CITY OF ALBUQUERQUE

**Re: Starbuck's
1000 Rio Grande NW
Request Permanent C.O. - Accepted
Engineer's Stamp dated: 6-17-16 (H13D021)
Certification dated: 9-7-16**

**Re: Starbuck's
1000 Rio Grande NW
Request 30-Day Temporary C.O. - Accepted
Engineer's Stamp dated: 6-17-15 (H13D021)
Certification dated: 3-24-16**

**RE: Starbucks and Burger King, Tract 338-B, 1000 Rio Grande Blvd. SE
Grading and Drainage Plan
Engineer's Stamp Date 6-17-2015 (File: H13-D021)**

Drawing file: H13D021 / H13D021_BP_Cmmt.pdf

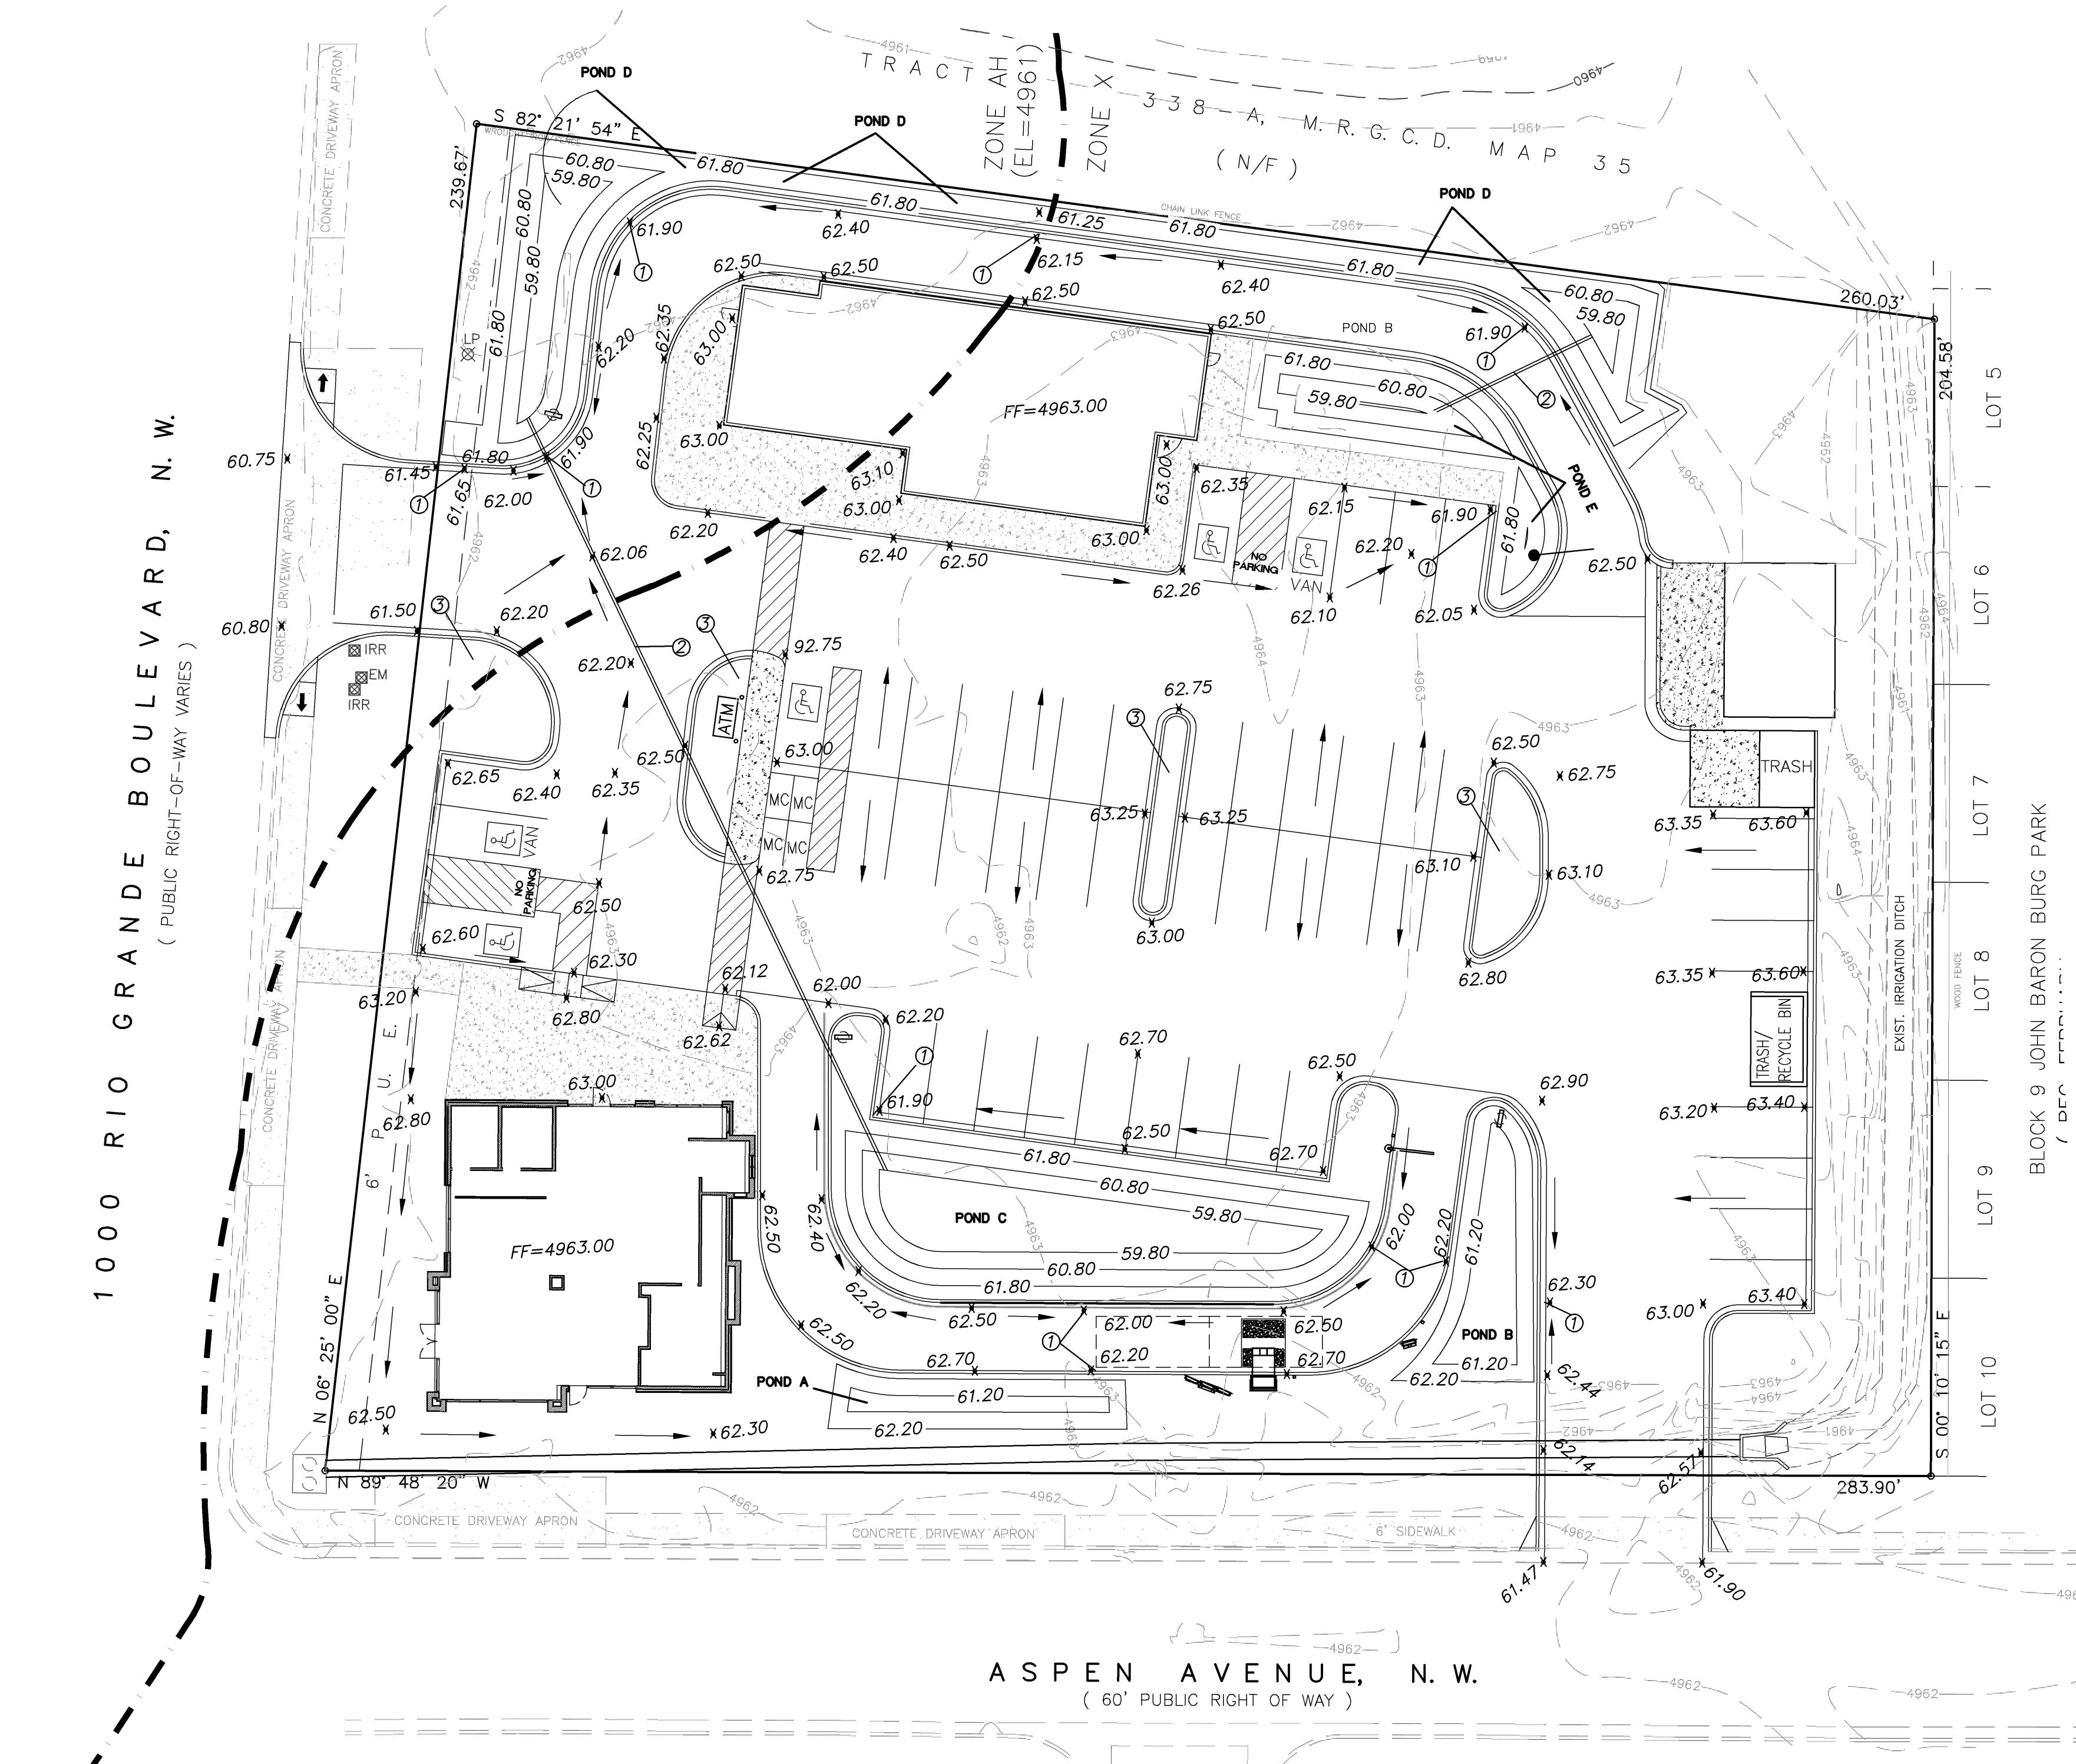
- 1) Provide a survey benchmark and existing spot elevations along the entire site perimeter. These are particularly important at the north and eastern boundaries. Also, provide existing curb elevations on Rio Grande Blvd.

- 2) A sidewalk culvert needs to be provided from Pond D to Rio Grande Blvd. Call out COA Std. Dwg. 2236 for the sidewalk culvert. In the valley, a maximum discharge rate of 2.75 cfs/acre from the site can be allowed, or ½ inches of runoff can be retained. It is preferable to discharge a rate of 2.75 cfs/acre from the site.

- 3) Indicate the floodplain boundary in the legend. Because you are constructing in the floodzone, please request a floodplain permit. An elevation certificate must be provided prior to Certificate of Occupancy. Additionally, for any fill you are bringing into the floodplain area, a compensatory volume of excavation must be provided. Please discuss how you are addressing this in the write-up.

- 4) If the pipe between Ponds D and C is meant to be an equalizer pipe, a larger size of pipe than 6" would be recommended. Explain the pipe's capacity to function as an equalizer pipe. Also, provide invert elevations at all on-site pipes.

- 5) Show the direction that the roofs drain. Indicate which ponds are retaining the first flush pond volume and note it on the plan view along with the first flush volume per pond.

- 6) Show the existing pipe and pipe size for the irrigation pipe under the new driveway to Aspen Avenue to demonstrate adequate pipe cover. Have a note for the irrigation ditch facilities to remain undisturbed.

- 7) Provide capacity calculations for the proposed sidewalk culvert and on-site curb cuts.
- 8) The scale on the plans is shown as 1:10, but it appears to be 1:20. Revise as needed.

- 9) It is not desirable to have a curb cut close to the north boundary of the site where it is too close to the property adjacent to the north. Is much of the roof draining to the north for the northern building? Could this flow be directed to the western side of the site where it is closer to the outfall and have a larger curb cut provided? In the write-up, discuss the impact of the on-site improvements to the property to the north or lack thereof.

- 10) Provide more spot elevations for the swale along the north side of the site and within the drive-thru between Pond D and E. The 92.75 elevation shown within the parking lot at the corner of one of the handicapped parking spaces is in error.

- 11) Provide the total for the pond volumes under the pond volume calculations at the bottom of the sheet. The summation of the pond volumes provided does not equal the pond volume calculations in the write-up. Take the language about draining to inlets out of the write-up if the site is not draining to any inlets. In the narrative for the "Existing Drainage Conditions", include a statement about historical flow patterns.

- 1) Bench Mark information and spot elevations along the entire site perimeter were added to the plan.
- 2) A curb opening is being used at the entrance at the 4961.65 elevation. Once Pond D has exceeded its volume then the runoff will overflow through this curb opening out to the entrance and then to Rio Grande Boulevard. The ½ inch of runoff is being retained as shown previously on the plan. The ½ inch runoff was calculated to be 2,512.76 cf.

- 3) Floodplain boundary was added to the legend. When the previous improvements were demolished about 6" of dirt, asphalt and dirt was removed from the site. When after the demolition the existing grades (+/- 4962.00) are higher than the floodplain elevation (4961.00). For the sake of conservancy, it was determined that over an area of 3,000 sf within the floodplain the ground has been raised an average of less than 6" (3,000' x .5') which will total to a volume of 1,500 cf. Therefore, total required retention volume would be (2,512.76 + 1,500) 4,012.76 cf. And the total retention volume provided on site is 5,996.77 cf which is more than 30% of additional volume. An "Elevation Certificate" will be submitted prior to Certificate of Occupancy. Since the existing grades are higher than the flood plain. A Flood Permit application is attached with this submittal.

- 4) The pipe connecting pond C to D is meant to be an equalizer pipe. The pipe size was changed to a 12" SD pipe. Orifice equation was used to calculate capacity. Inverts were called out for the 12" pipe under the circle note 2.

- 5) Direction of the roof drains are shown on the plan. First flush volumes are called out for each pond.

- 6) Existing pipe and pipes size for the irrigation pipe under the new driveway to Aspen Avenue are shown. There is 12" of cover over the irrigation pipe at the driveway. A note has been added that the ditch facility will remain undisturbed.

- 7) No sidewalk culvert is being proposed. Please see response number 1. Capacity calculations for the curb cuts are shown on the plan.
- 8) Scale of the drawing was changed to 1"=20'.

- 9) Half of the roof does drain to the north and the sheet flows to the east and west to two low points. The runoff does drain to the west and to the east to Pond D. Pond D is designed to overflow out the entrance. This development does not create any impact to the north. In fact some of the runoff is cutoff and will not drain to the north after the development of this site.

- 10) Additional elevations were added to the along the northerly property line. We have the proposed pond D with the high point in the middle. The 92.75 elevation appeared to be correct.

- 11) Total volume was included. The summation of the pond volume was corrected. The language regarding the drainage to the inlet was removed. Historical flow patterns was included in the narrative for the "Existing Drainage Conditions".
